Please upload as consultation for Y/ 50/20/DOC

I attach the plan sent from Bright Plan Civils, with inspection chamber now being a catch pit.

Y/50/20/DOC at Rookery Cottage.

NOTES

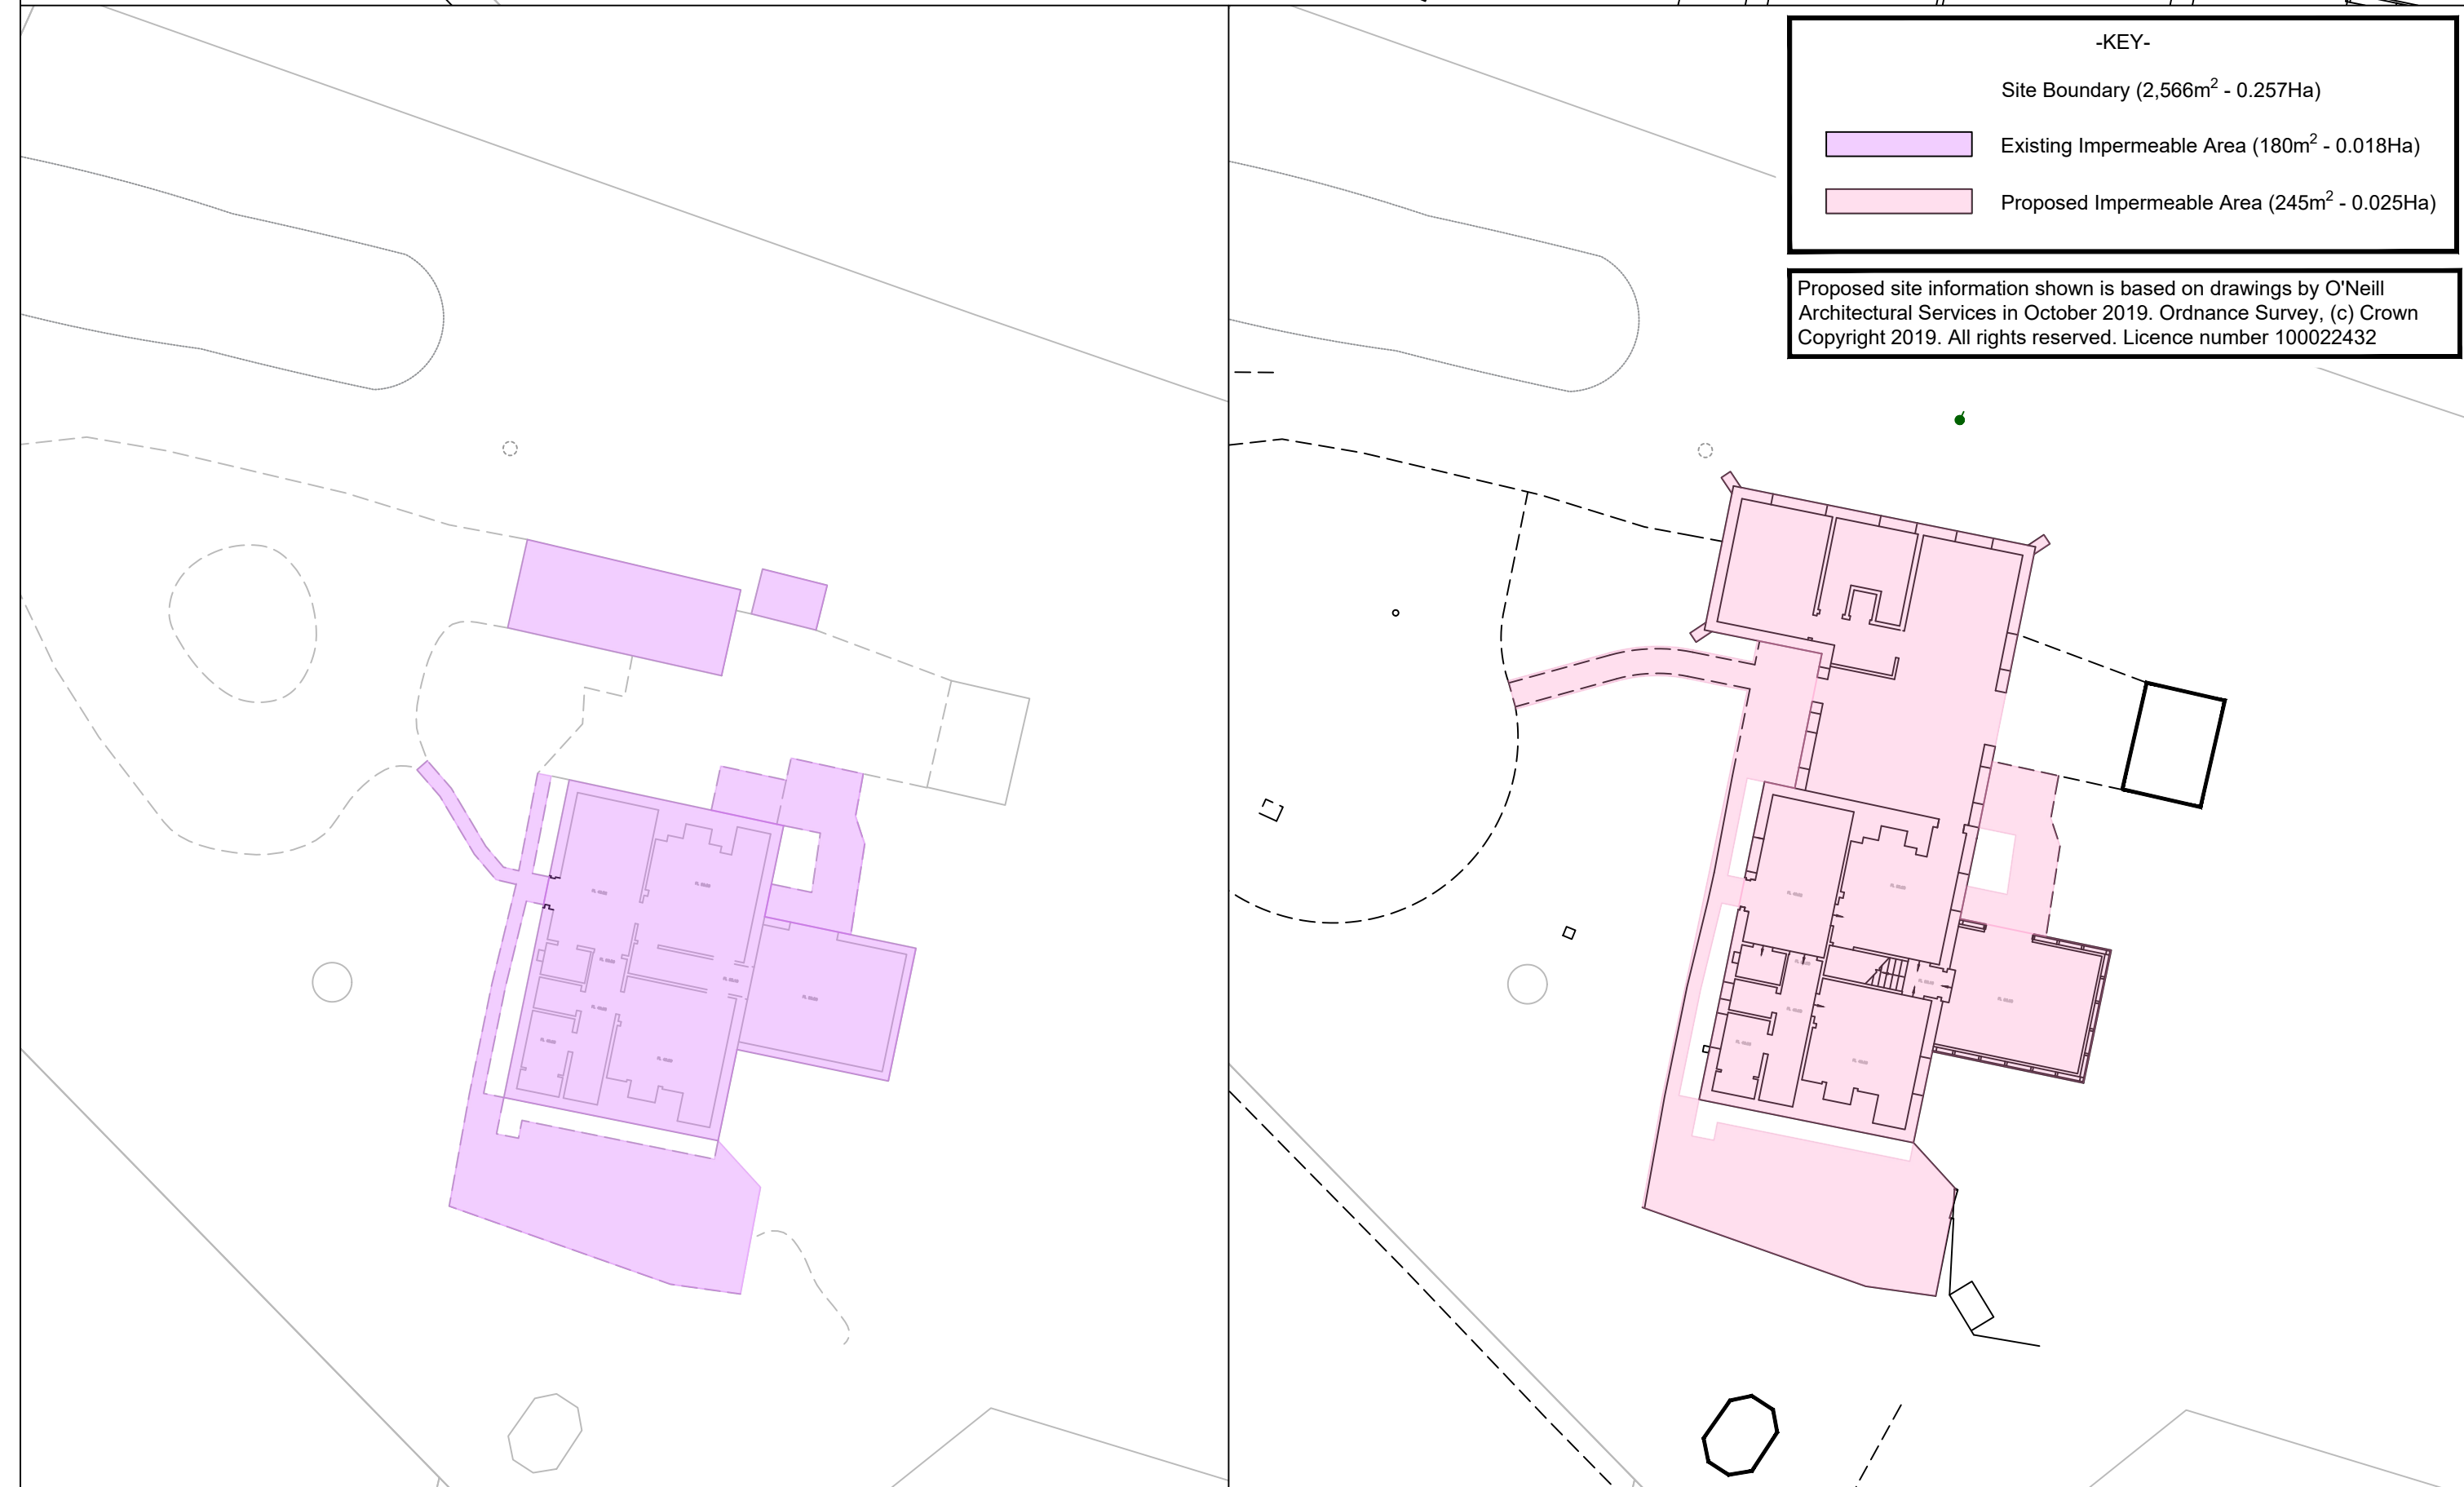
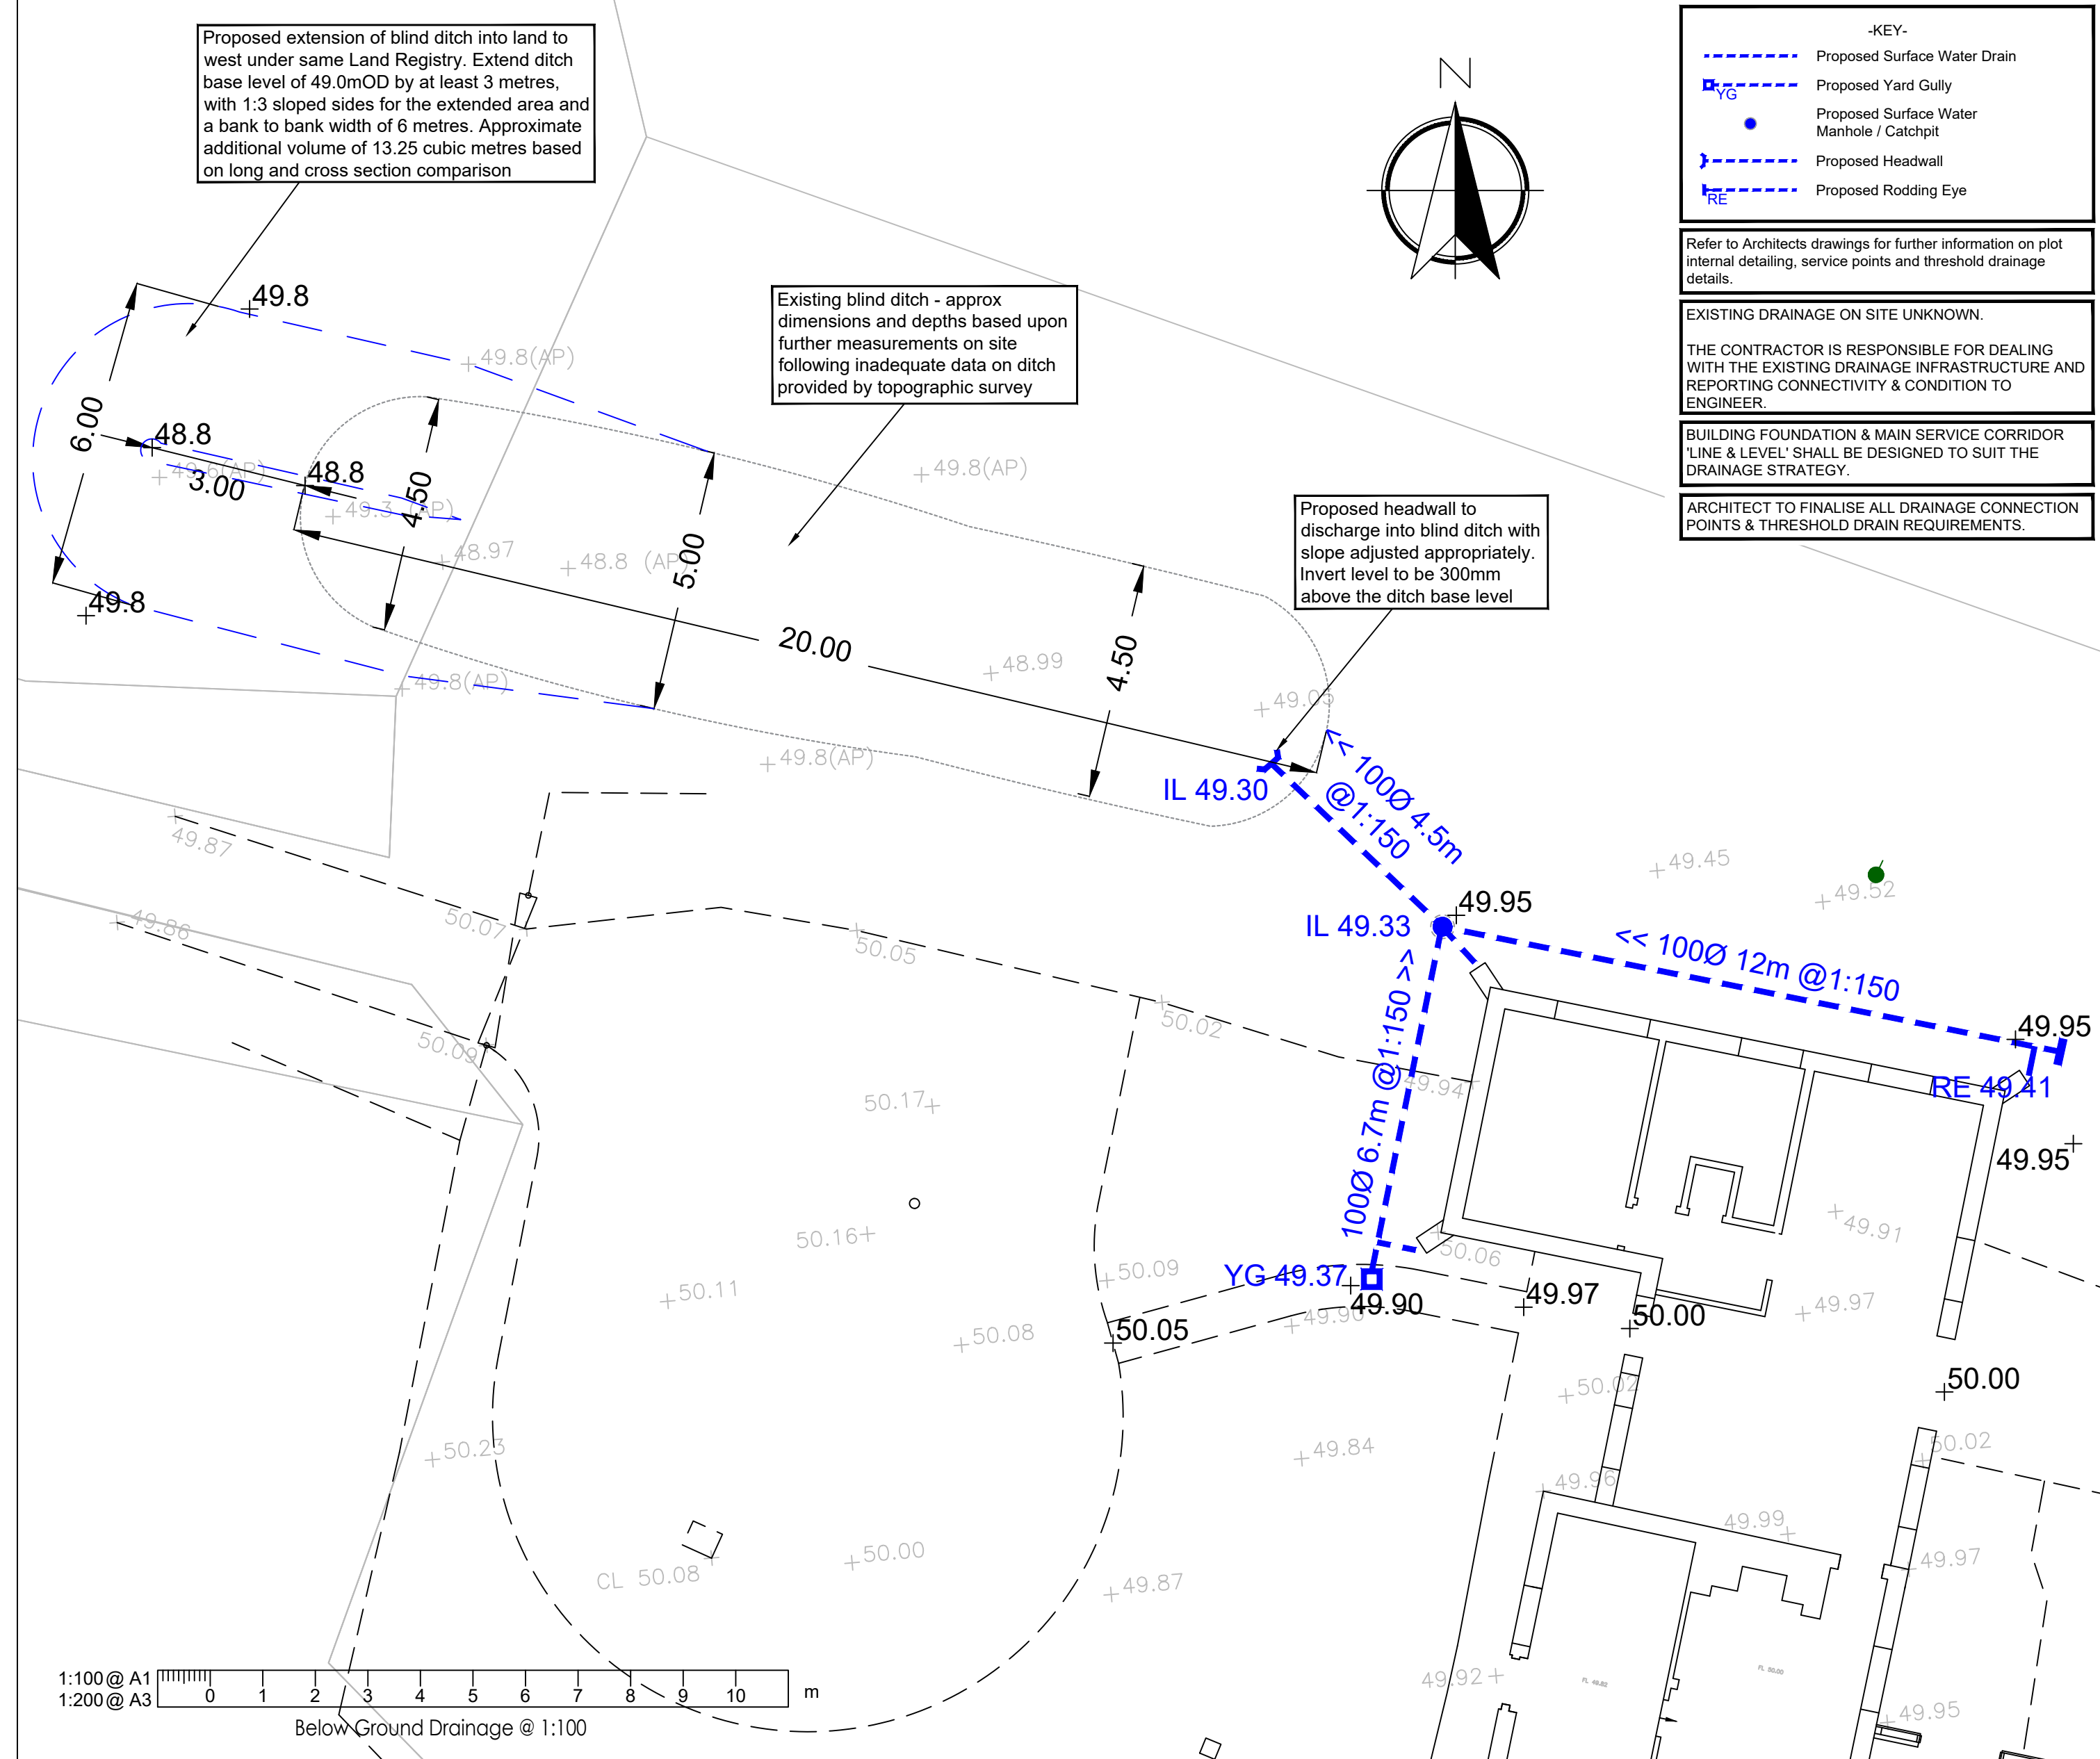
'Please amend the inspection chamber to a catch pit (provide a sump). Once this is done I will be happy to recommend discharge of condition 3'.
